Arun District Council
Arun Civic Centre
Maltravers Road
Littlehampton
West Sussex BN17 5LF
Planning & Building Control General Enquiries
Tel: (01903) 737756 Fax: (01903) 730442
Dx: 57406 Littlehampton
Minicom: 01903 732765
e-mail: planning@arun.gov.uk
website: www.arun.gov.uk/planning

Application No: R/60/22/PL
Site Address: The Windmill Inn Mill Lane Rustington BN16 3JN
Description of works: Extension and remodelling of existing public house to form hotel with 20 No bedrooms and associated parking and landscaping. This site is in CIL Zone 4 (Zero Rated) as other development.

Thank you for your internet representation made on 1st April 2022 which has been recorded as an objection with the comments as follows:

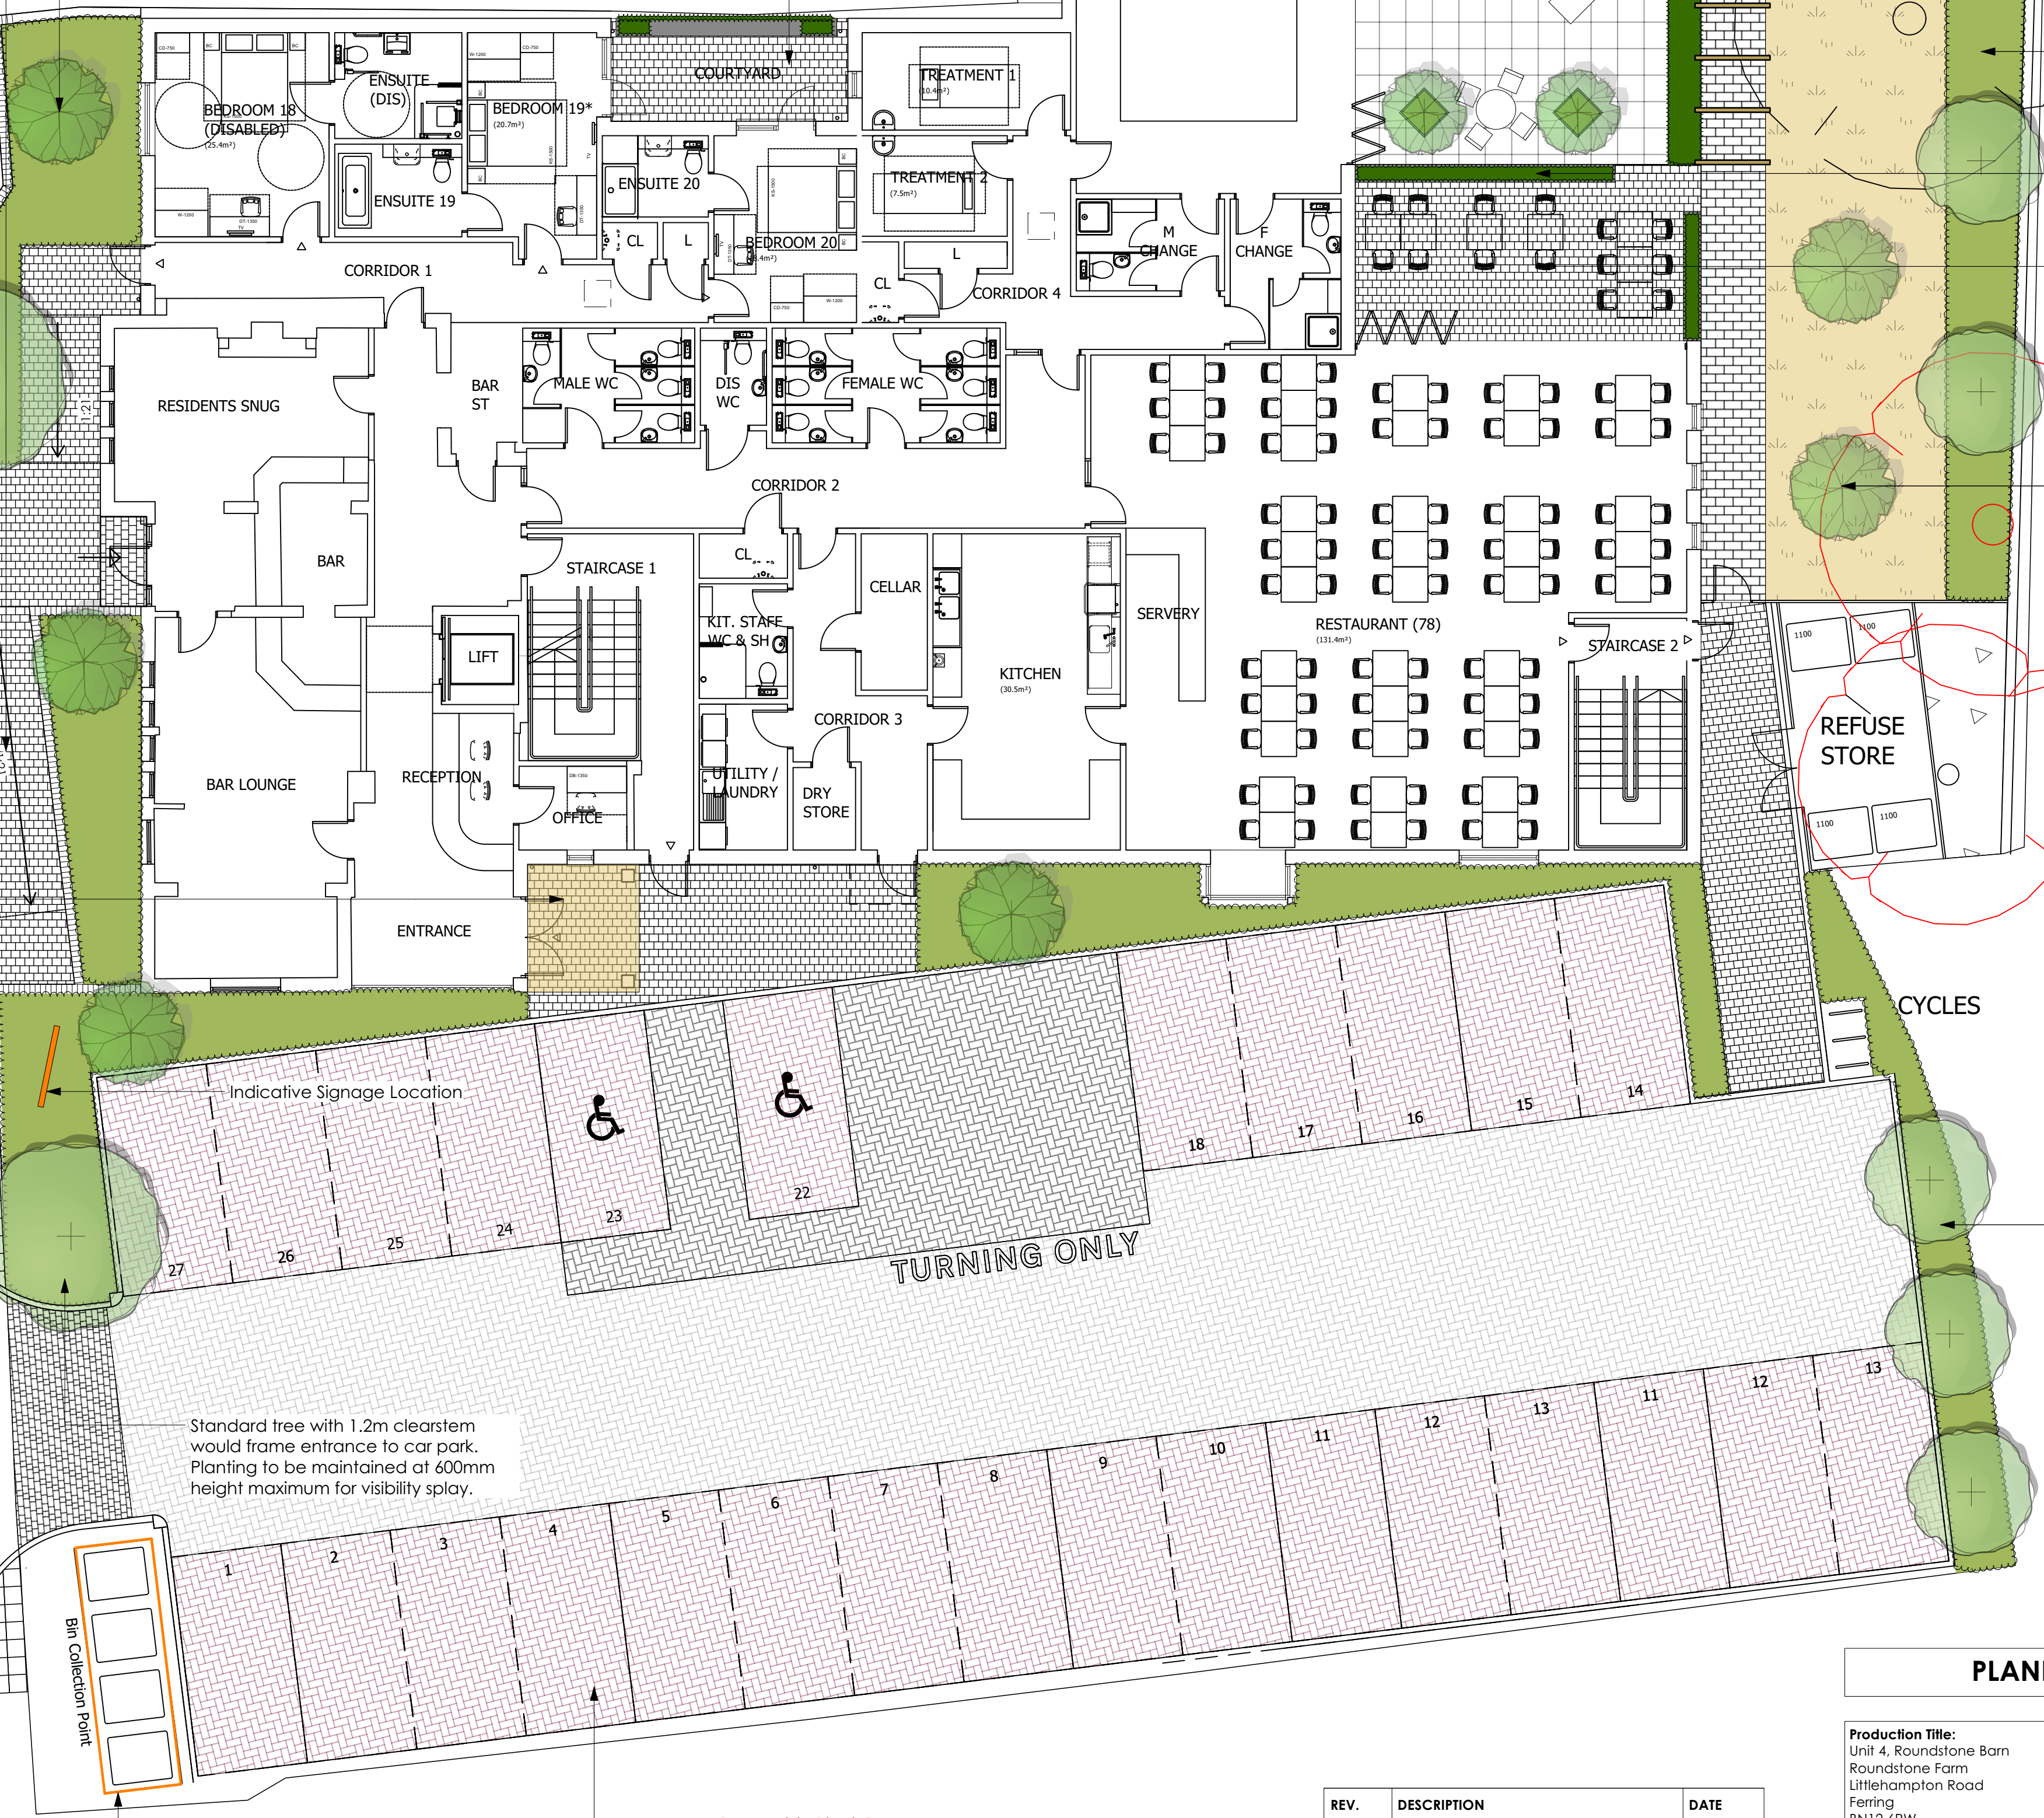
It is inconceivable that by adding a 20-room hotel, incorporating a restaurant with 78 seats plus the 14 extra seats (shown as an overspill area in the landscape strategy master plan 1), keeping the bar, adding a pool and spa, an outside bar with bar b q area and deck for events will lead to a reduction of traffic movements! Surely the whole point of this large development with a possible hotel and 92 seat restaurant is to increase business and the number of people using it and thereby vehicle trips.
